ADL Traffic and Highways Engineering Ltd

Re: A38 DERBY JUNCTIONS PROJECT: DEADLINE 3 SUBMISSION

1.0 Written Summary of Oral Representation

CUSTOMER TRACKS

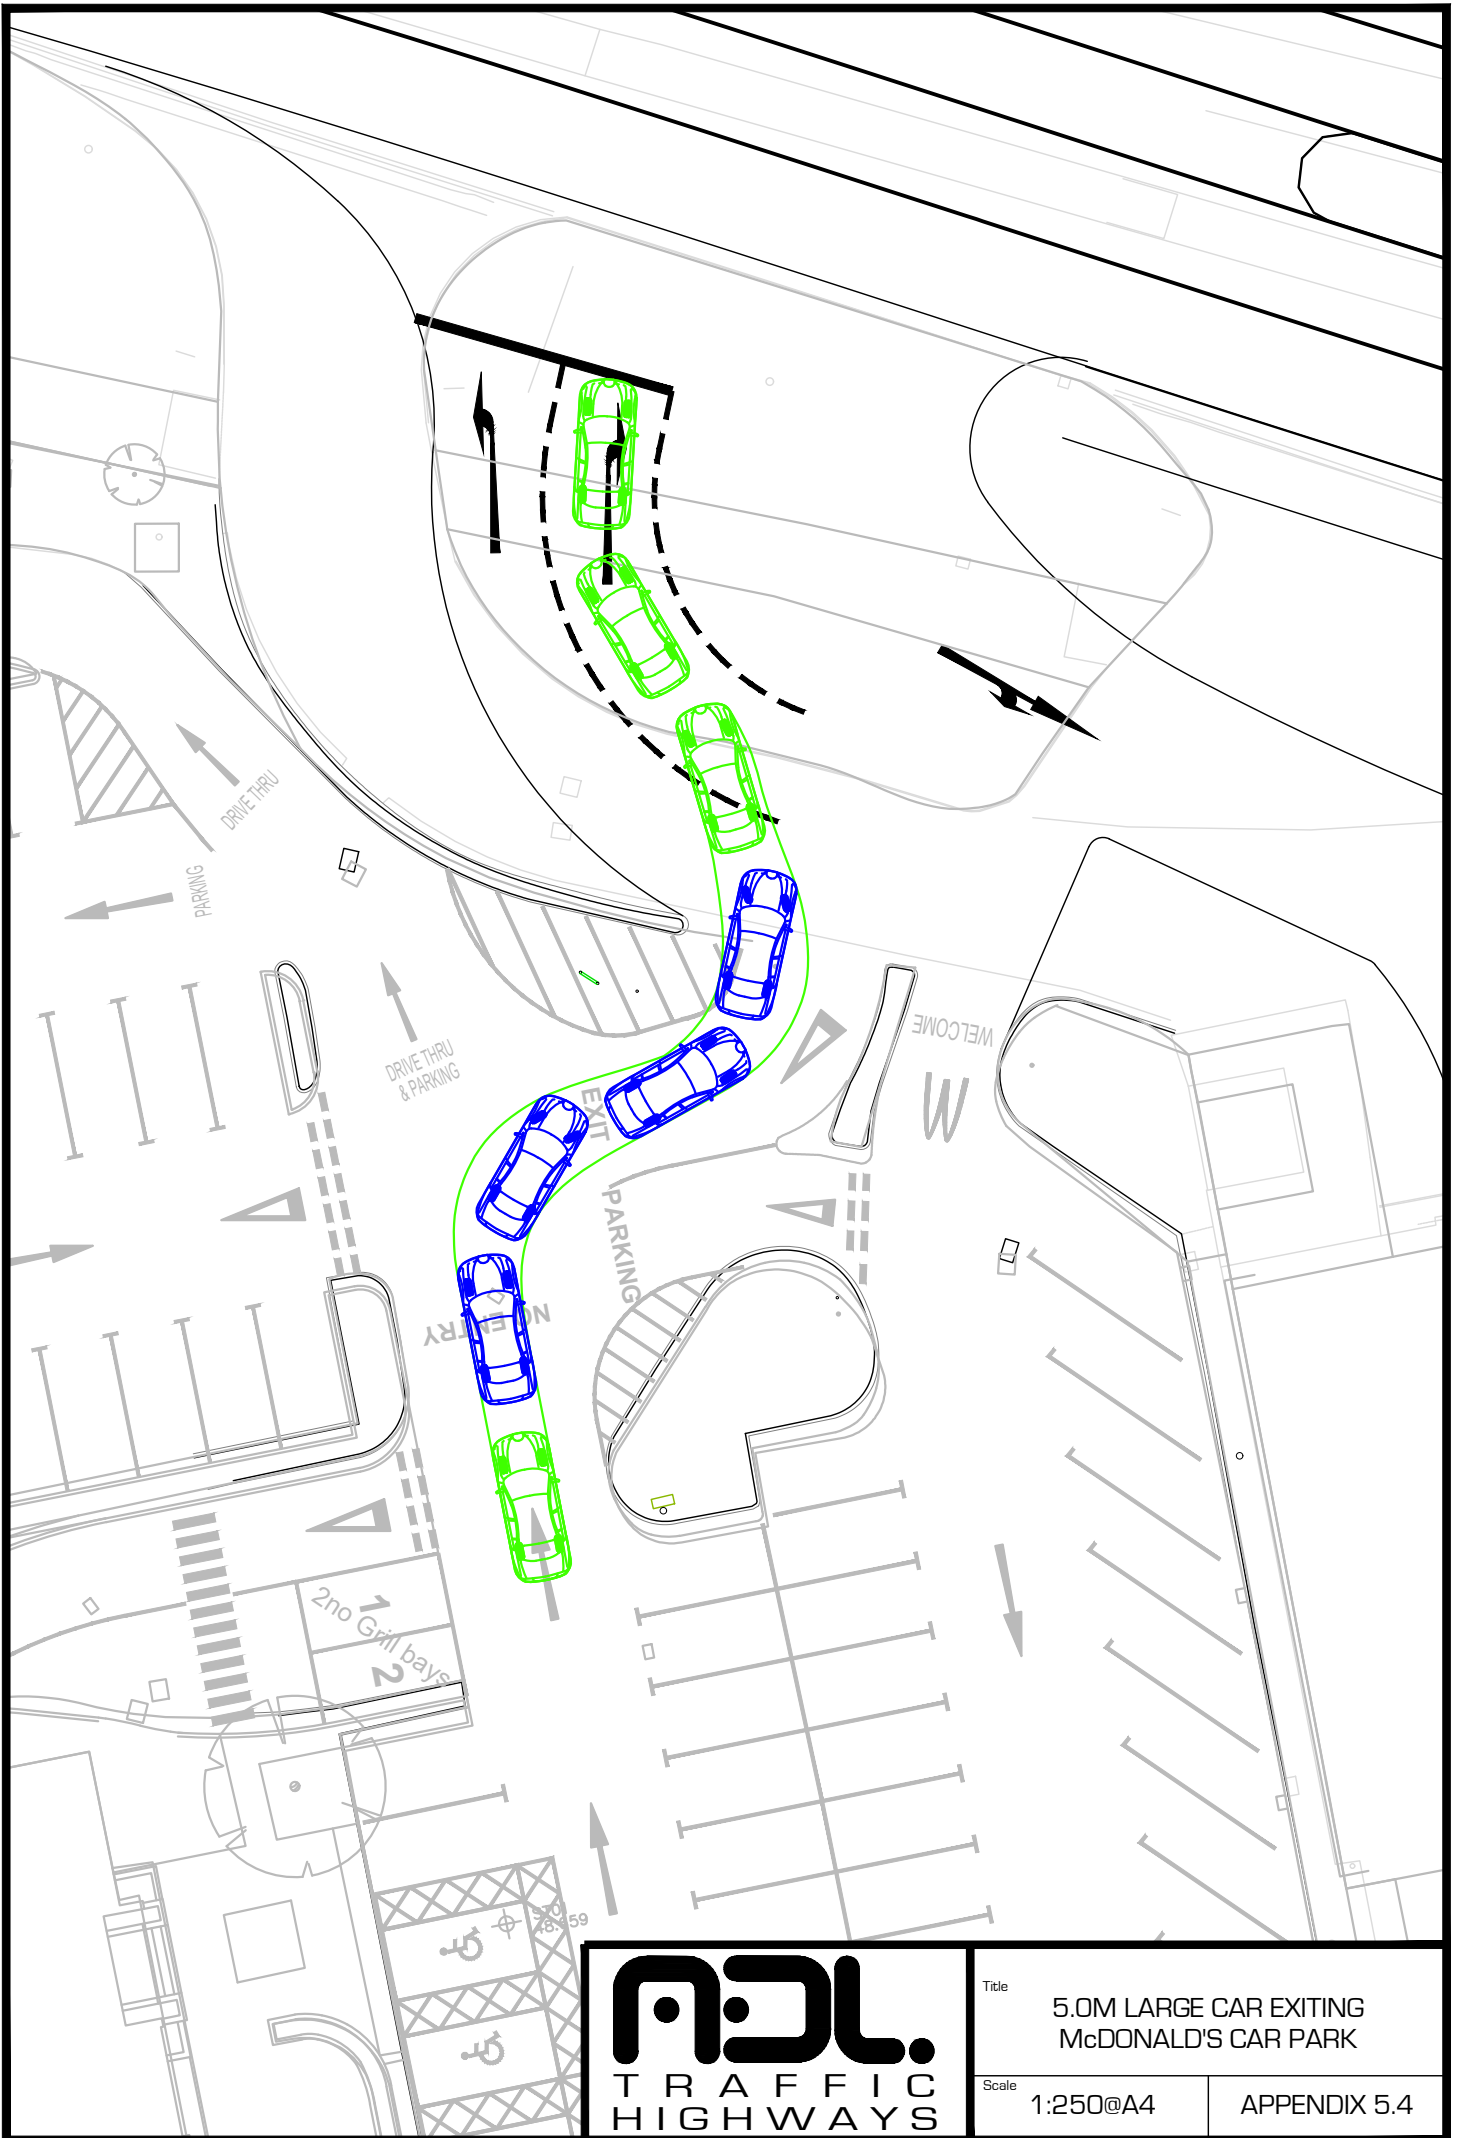
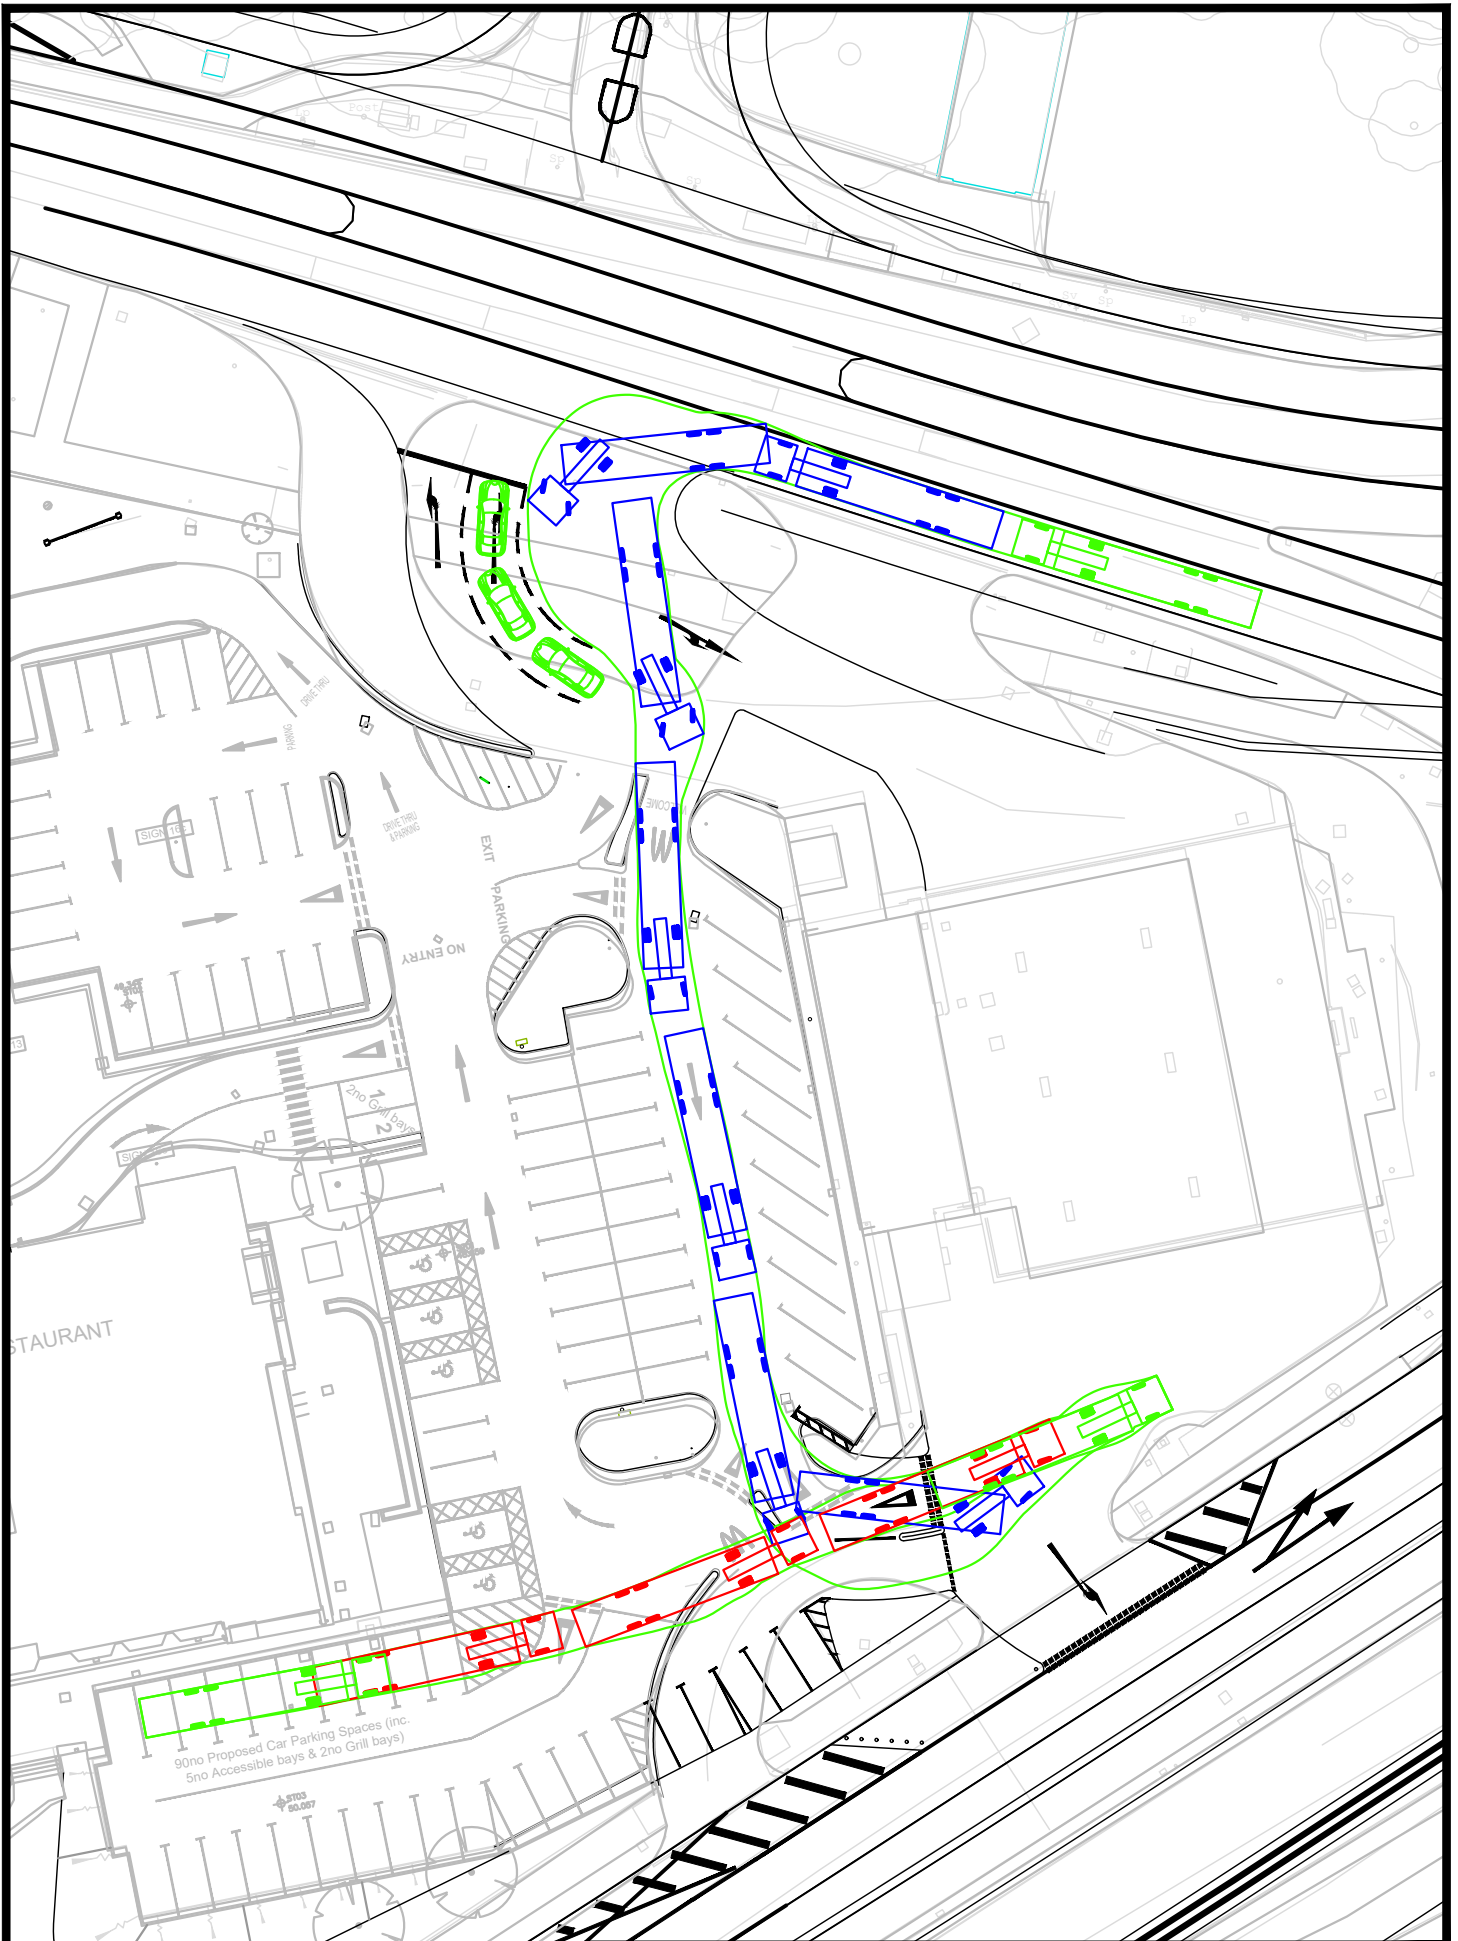
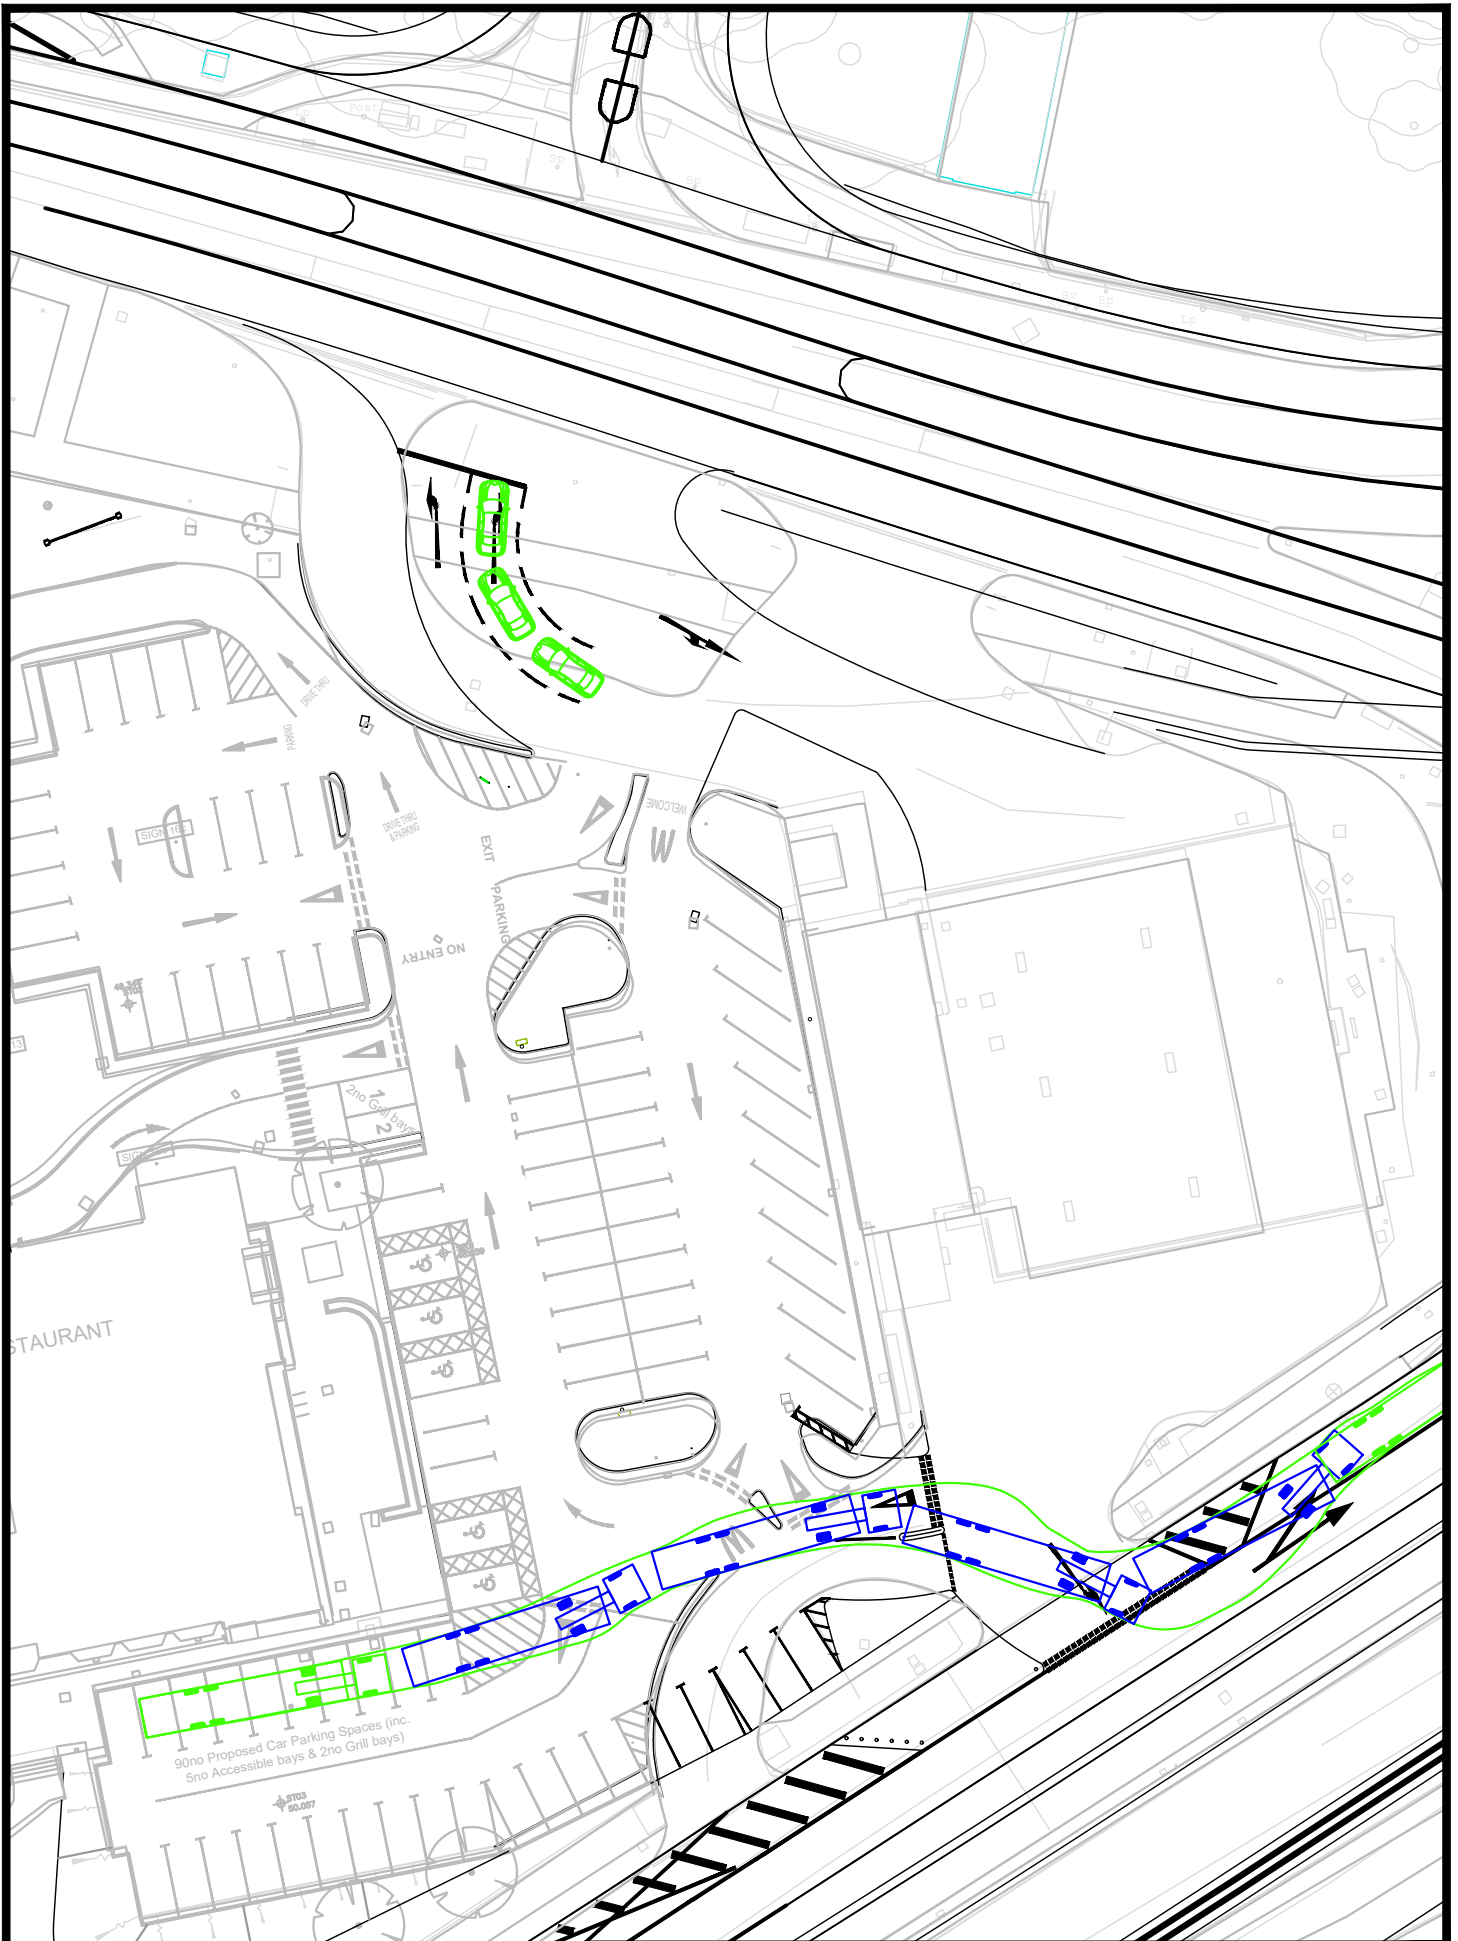
Swept paths were included as Appendices 6.1 and 6.2 of our Written Representation. These show the full size articulated delivery vehicle entering and exiting the site. We note that the left turn into the site from the A52 is very tight and the inside track of the vehicle envelope touches the kerb face during the turn in.

The driver is then required to enter the north end of the McDonald's customer car park and travel south down the parking aisle before turning onto the Euro Garages forecourt. Changes will need to be made to the existing kerbing at the north and south ends of the car park to avoid the HGV overrunning these existing elements. From here the vehicle reverses back to the offload position, similar to the existing situation.

The exit manoeuvre was shown at Appendix 6.2 of our Written Representation and would be as per the existing situation.
